Agency Review Comments

Rolling Hills PUDSP

PUDSP199

ROLLING HILLS RANCH FILINGS 1-3 AT MERIDIAN RANCH PUD DEVELOPMENT PLAN / PRELIMINARY PLAN

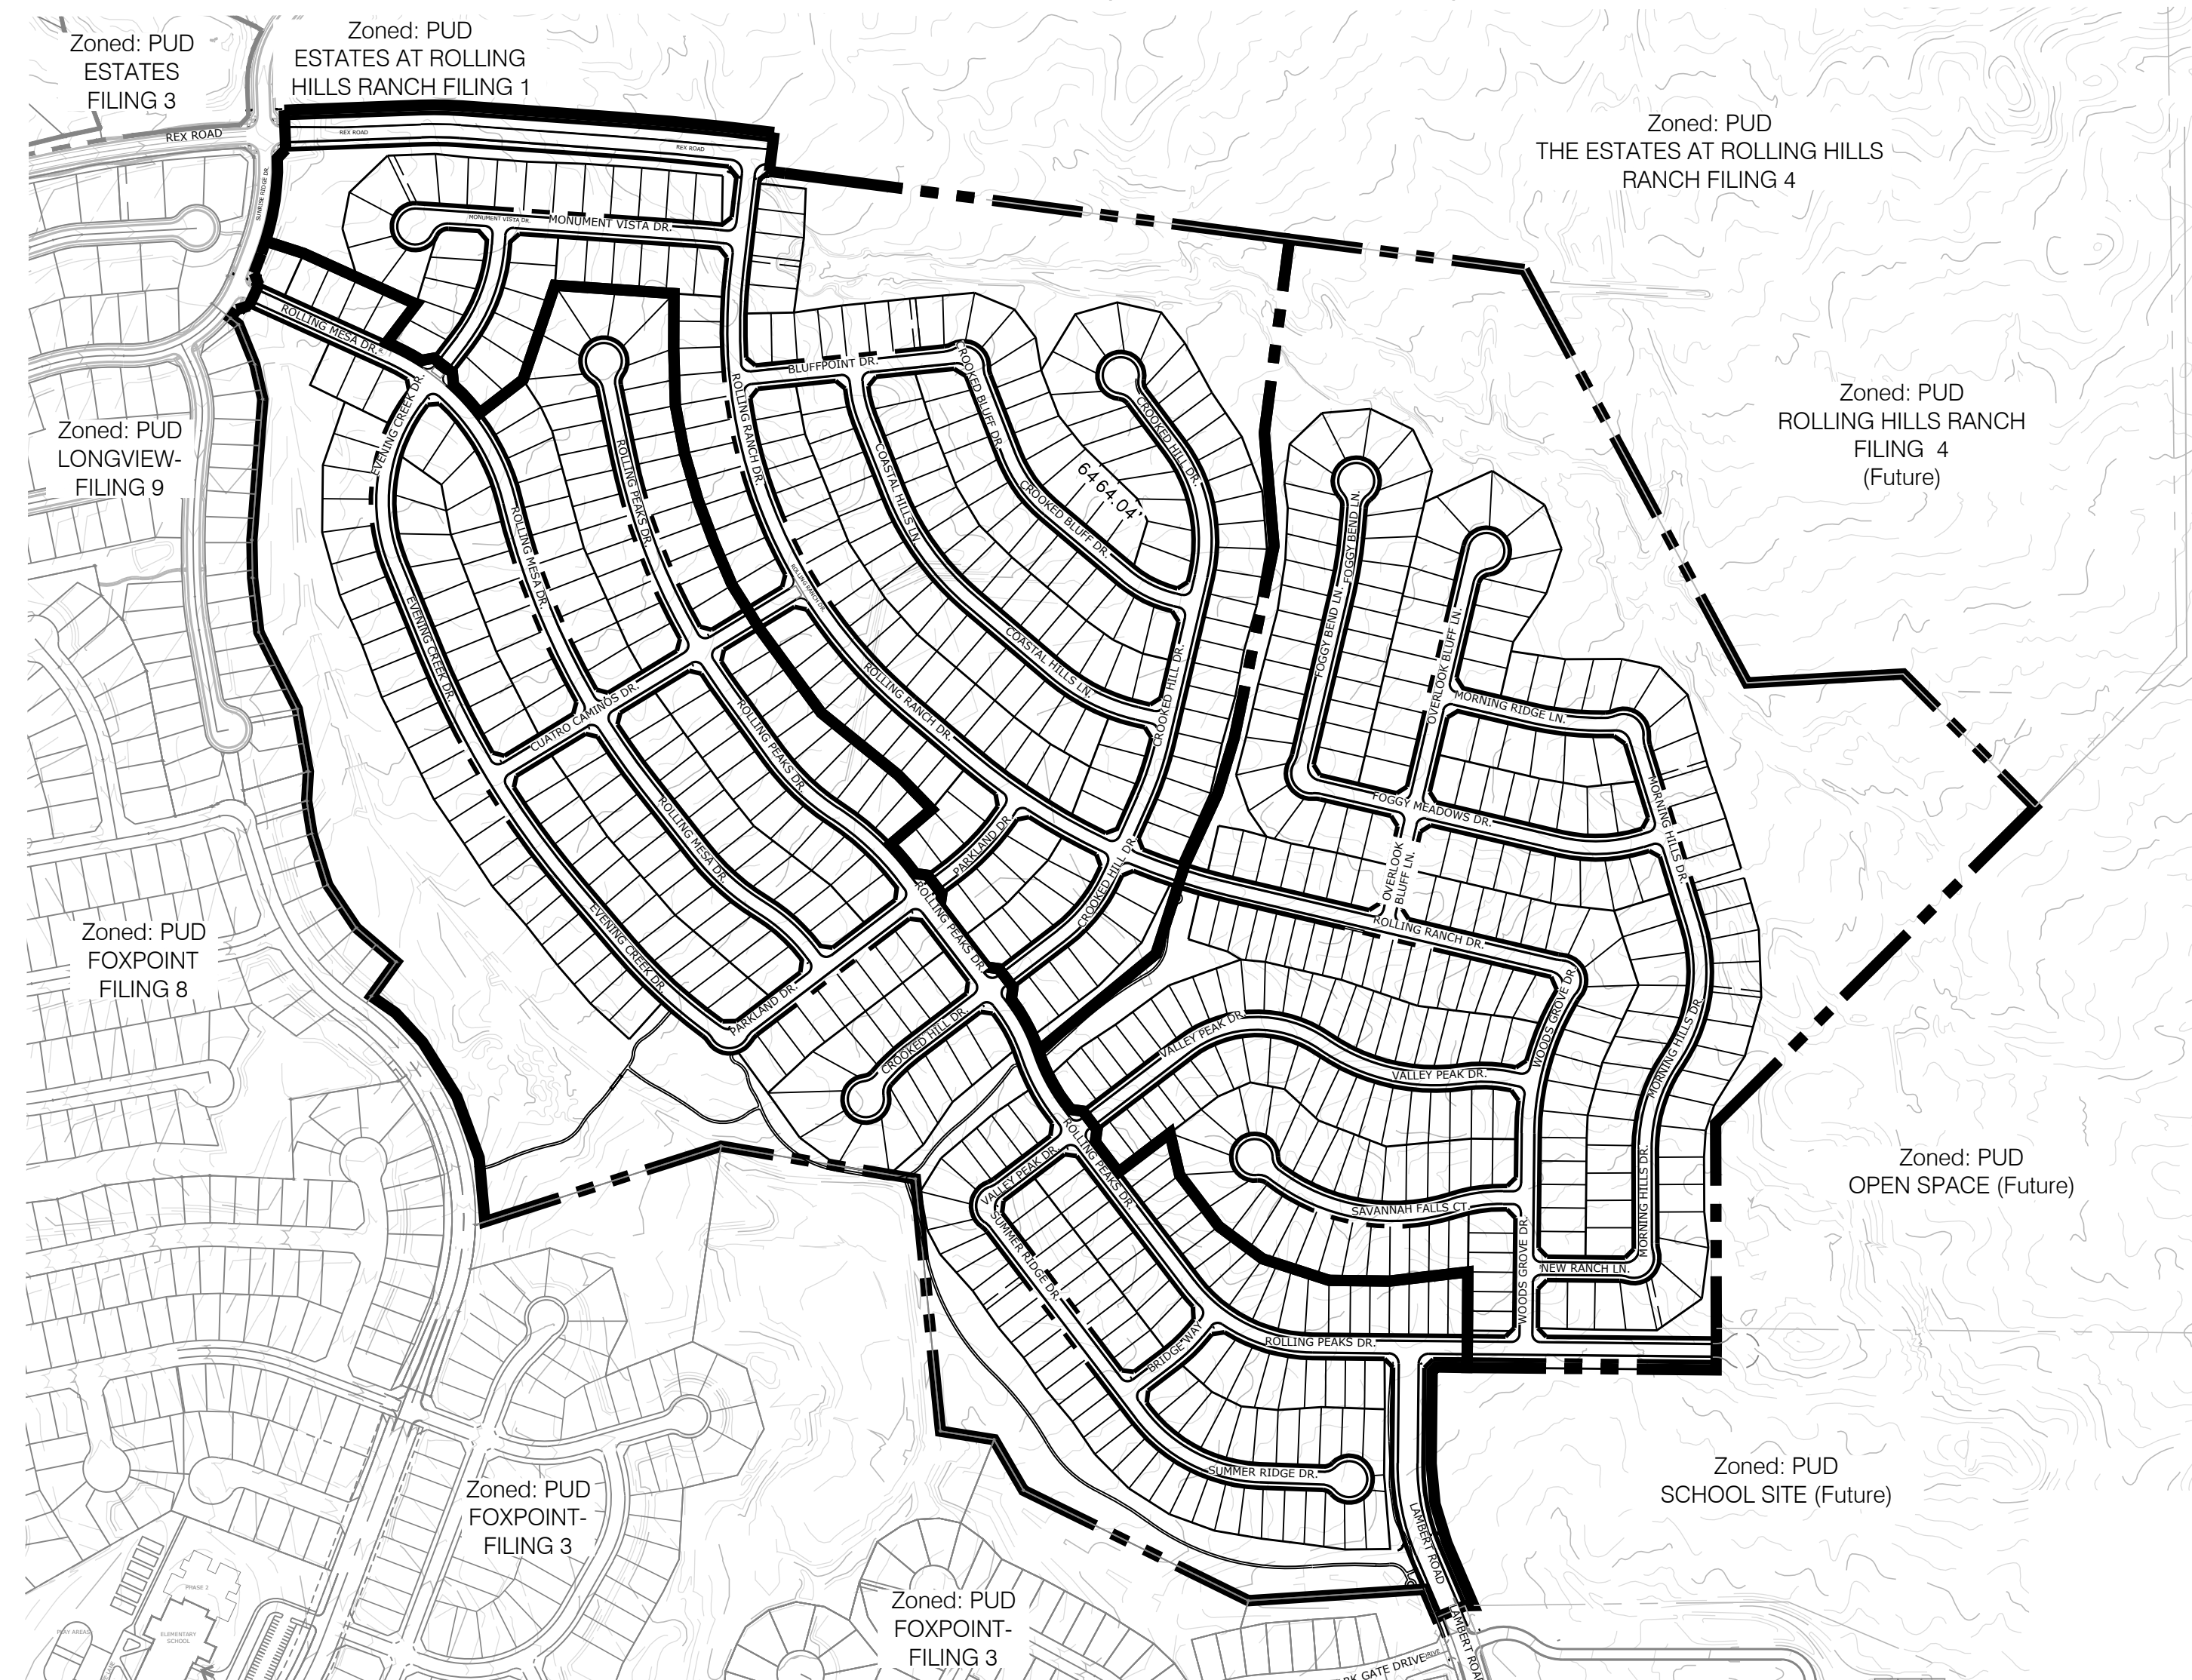
General Note 15 on Sheet 1 of the PUD Development Plan / Preliminary Plan (N.E.S. Inc., October 19, 2019), Geologic Hazards Note, lists "artificial fill, loose soils and expansive soils" as geologic conditions

impacting areas of the proposed subdivision. Shallow groundwater should be added to this list.

NES RESPONSE:
Comments acknowledged and understood that additional investigation after overlot grading may be needed.
